Please could you upload the correspondence below and the attachments to the application folder BE/70/20/DOC as additional drainage information?

Subject: RE: RE: BE/70/20/DOC Drainage Planning Comments [Filed 20 Aug 2020 08:10]

Condition 6- surface water drainage design

PHASE 1A - LIDL SITE
ATTENUATION POND DETAIL

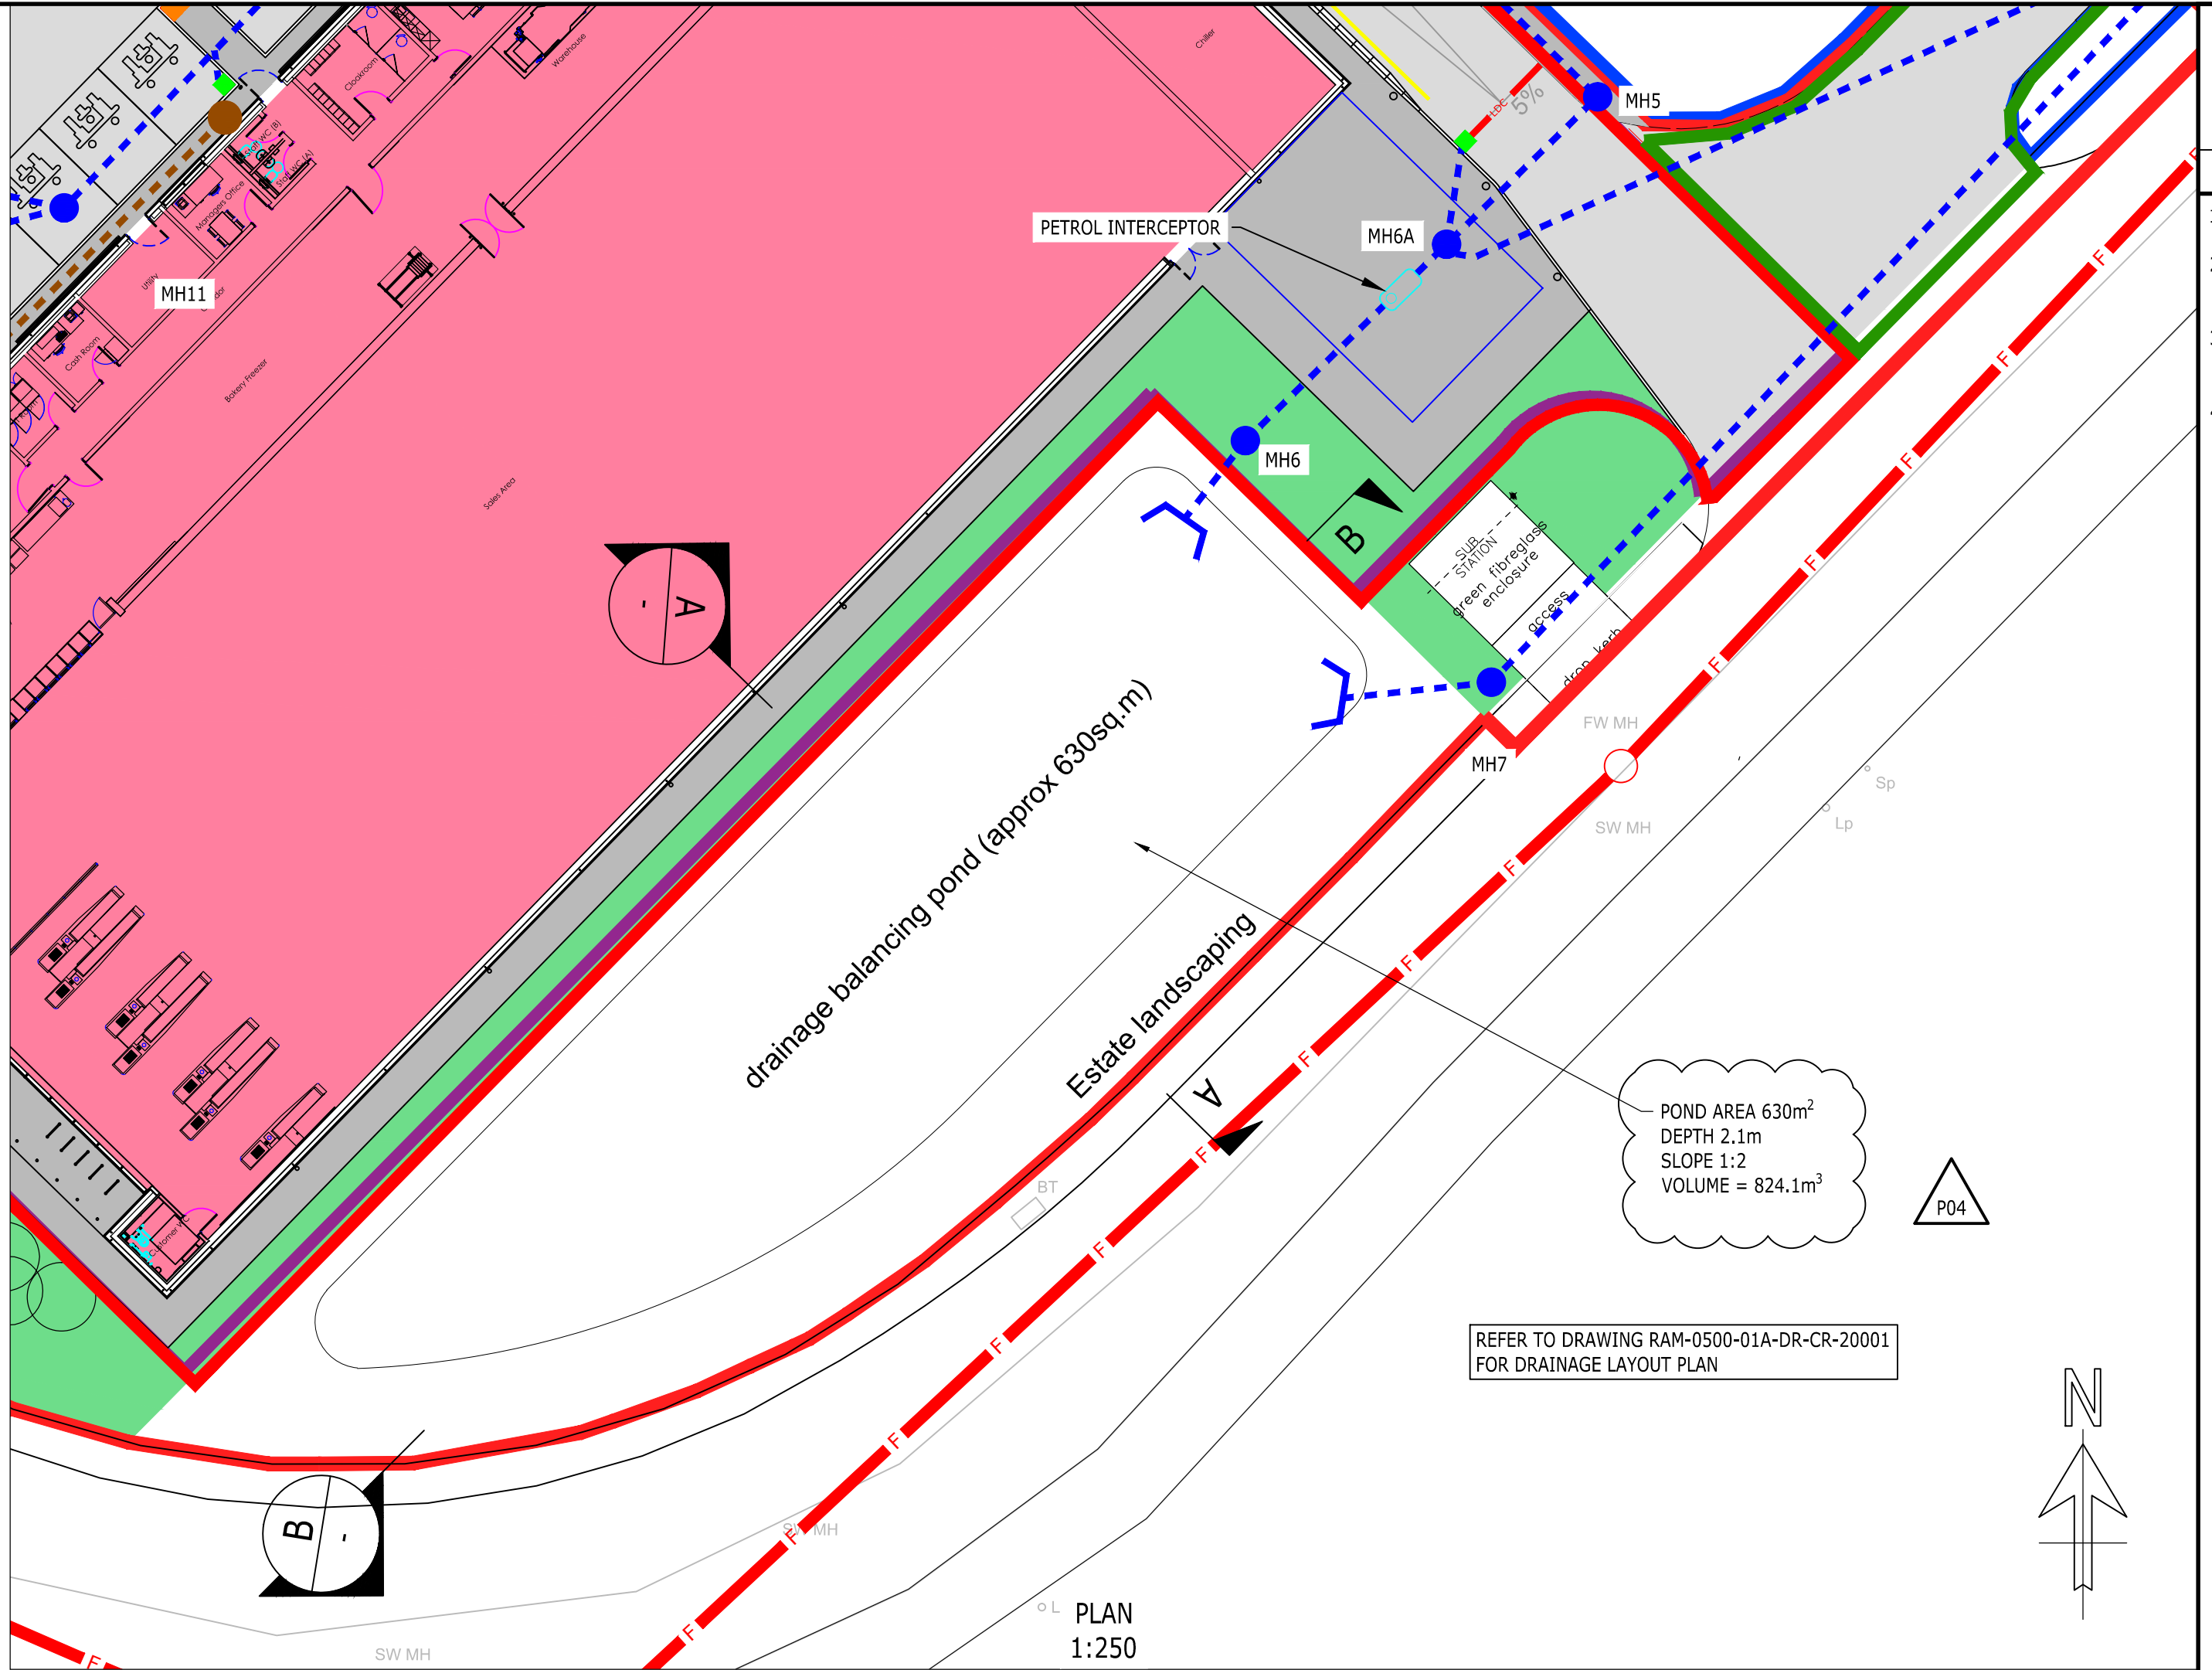
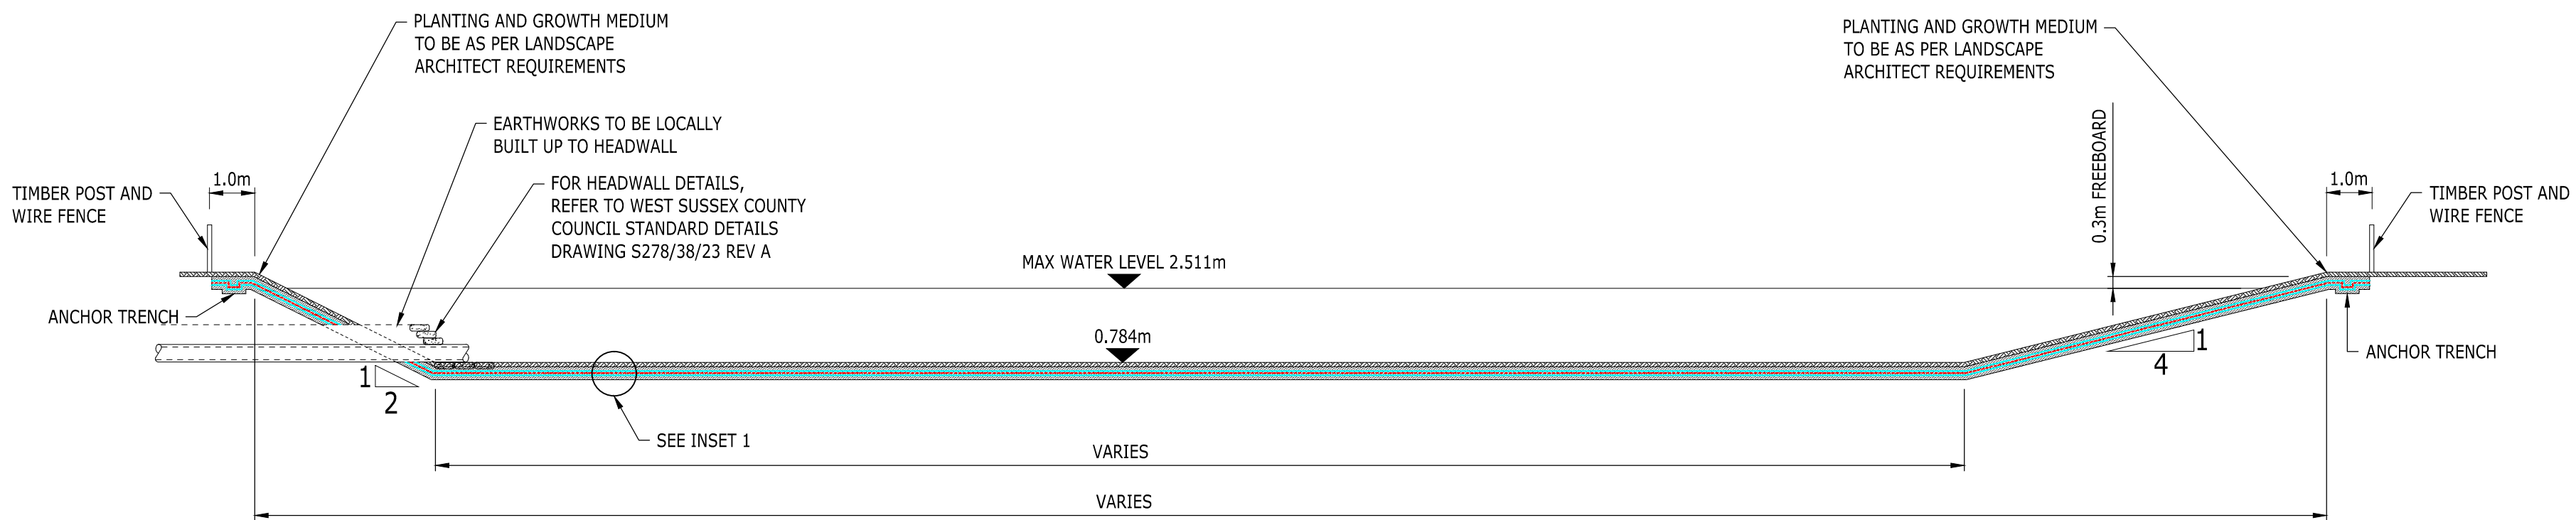
5. Pond cross sections have been provided, these indicate slopes are to be set to 1:2. 1:3 slopes should be provided. *As per point 2 this pond cross-section was proposed and shown to ADC previously and no objection received. We have no further space in the area of the pond to alter to 1 in 3 side slopes as this would reduce the overall storage volume and cause flooding. Can any slackening of slopes occur, please see comment 8 below where additional storage is suggested. You have room on site to provide additional storage, you are just opting not to currently.*

6. It appears that a post and rail fence is proposed 1m from the top of bank of the attenuation basin. We require a 3m clear buffer around the basin to facilitate future maintenance. *3m easement has been provided in regard to distance to any structures. The post and rail fence has been provided as a safety measure to prevent access. Although this is within the 3m it is thought it would be best to keep this and maintenance can still be carried out by the private maintenance consultants. Maintenance manual should acknowledge the location of this feature and the potential requirement for its dismantling and reconstruction to complete maintenance.*

We do not believe we can slacken the pond side slopes any further as the impact on storage would be to drastic and no further space is available to expand the pond area. Considering this is our main storage component we believe the 1 in 2 side slopes should be retained and we can make reference to the 1 in 2 side slopes in the maintenance manual so care is taken during any maintenance procedures. Okay, proceed with this.

Noted, we will update the Maintenance Manual to ensure this is mentioned. Awaited.

CLASS 1 FULL RETENTION INTERCEPTOR

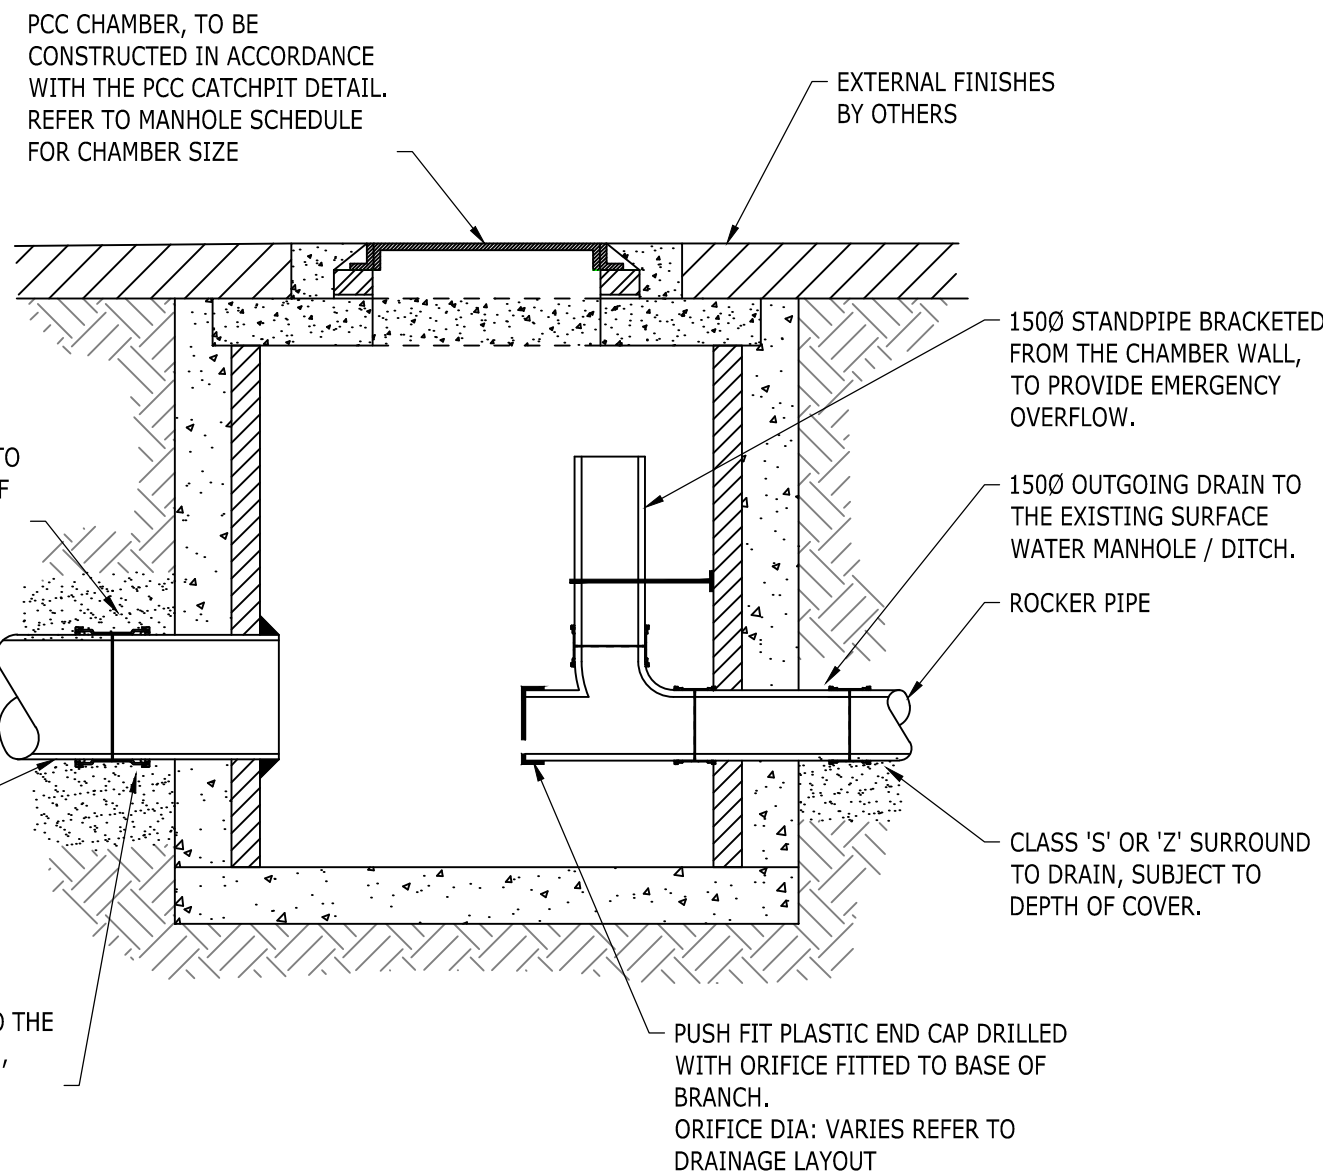
8. Please detail what type of petrol interceptor is proposed and how the scheme meets the requirements of CIRIA C753 chapter 26 in terms of hazard mitigation indices.

This may also help to reduce the size of basin required to ensure side slopes meet minimum requirements. A Class 1 Bypass separator will be required and this will work in conjunction with the dry pond and trapped gullies to mitigate against pollution/contamination risk to Oldlands Farm Ditch. *Please clearly indicate how this will achieve the required pollution mitigation indices for events up to and including the 1 in 1 year event plus cc.*

We will complete the Simple Index Approach from Ciria C753 Chapter 26 to ensure we have adequate treatment facilities prior to outfall. If detention basin combined with separator and trapped gullies/chambers is not sufficient we will incorporate a vortex separator (such as Downstream Defender) to further protect the downstream receptor. *Further details awaited.*

# ELEVATION OF HEADWALL OUTFALL TO POND / SIDE OF DITCH

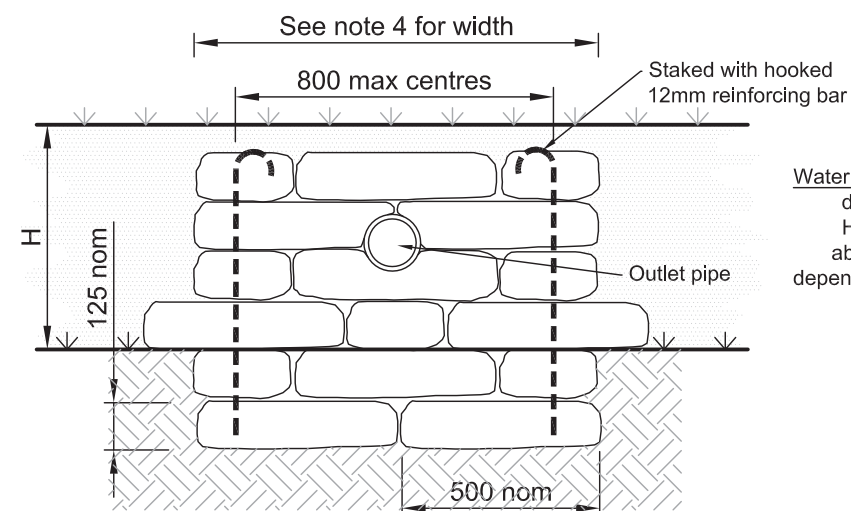
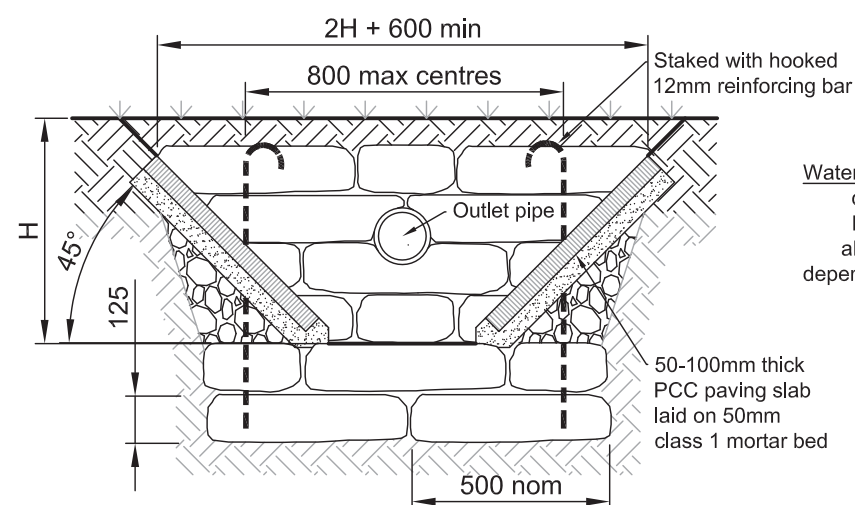
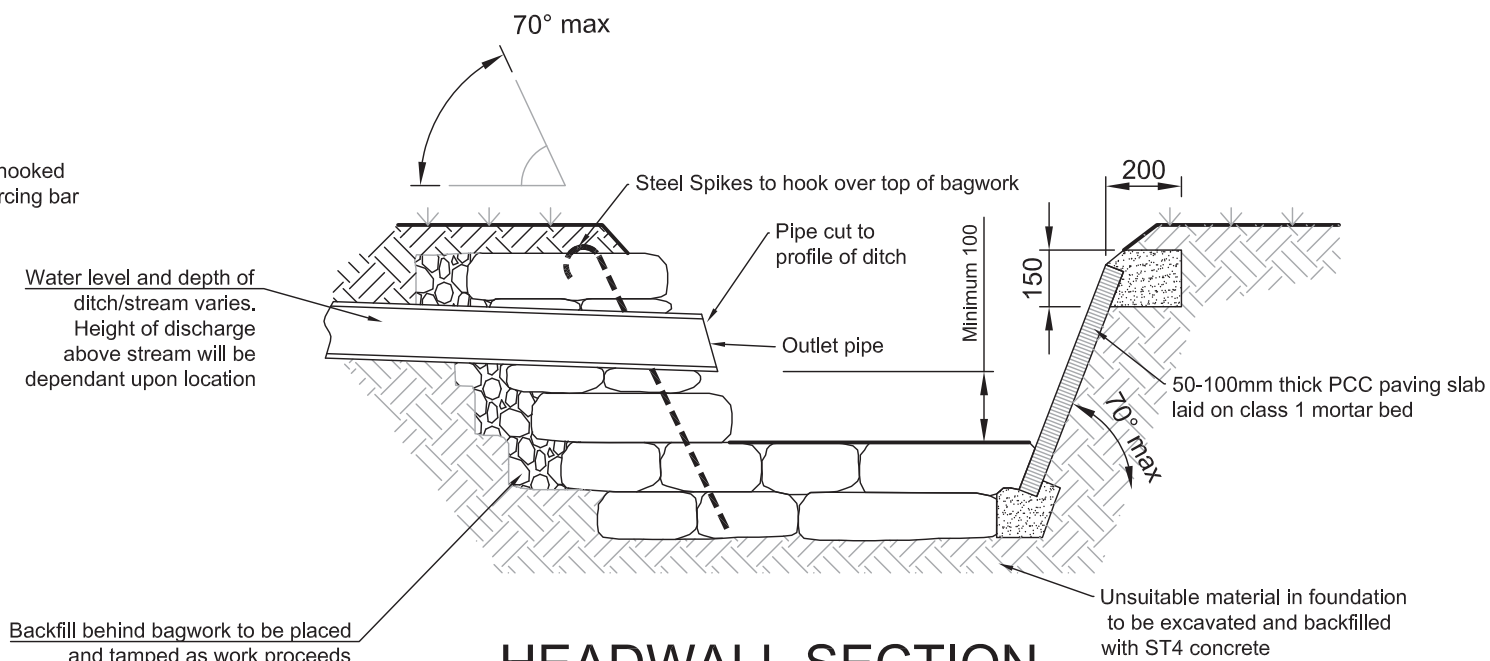
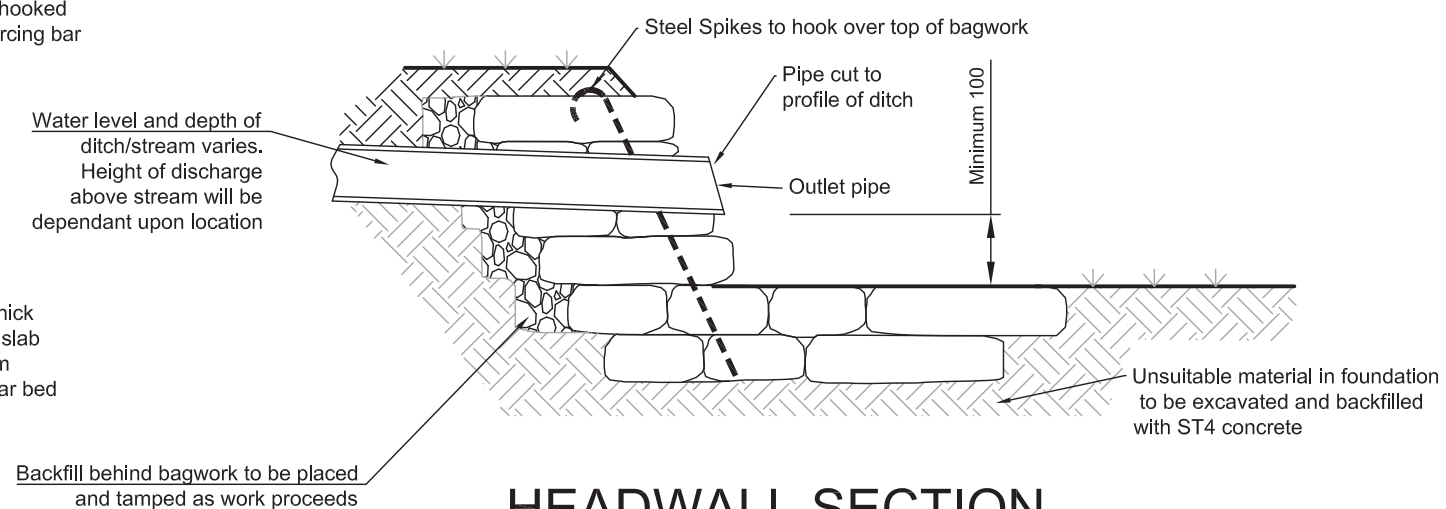
7. Please provide site specific construction detail drawings for manholes, silt traps, pipe bed and surround, channel drains, gullies, headwalls, flow control chambers, interceptor etc. *Details have been referenced as WSCC details and necessary items updated in correspondence with Paul Cann for the outfall structure. Details must be site specific and included as part of this application.*

Noted, specific details will be provided for hydrobrake manhole and bespoke items such as additional flow controls provided and cellular storage when added. Please confirm if there are further details that need to be bespoke i.e. not covered by the WSCC standard details? I assume the outfall is covered as agreed with Paul. Specific construction detail drawings of the latest outfall drawings, flow control devices, and storage features.
